R1175/12.

I am writing in connection with the proposed demolition and rebuilding of 46 Seafield Road, Rustington.

NORTH 1/100

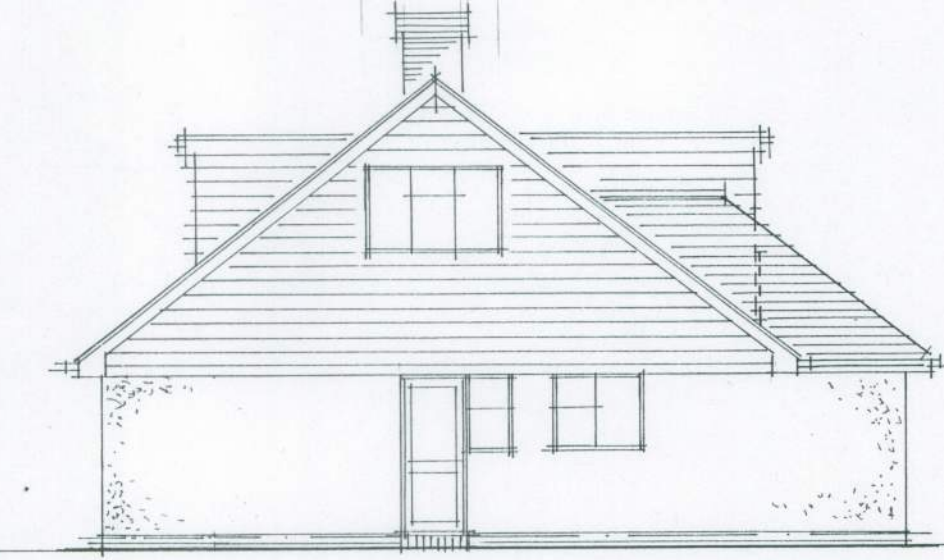
3. A consideration of planning permission should be that any costs relating to damage to my property or the surrounding boundaries should also be paid for by Mrs Kennedy insurance cover.
4. In the proposed plans one of the upstairs windows will be looking directly into my garden, which at present is totally private. I will plant a substantial tree to afford us some privacy in the North East corner.
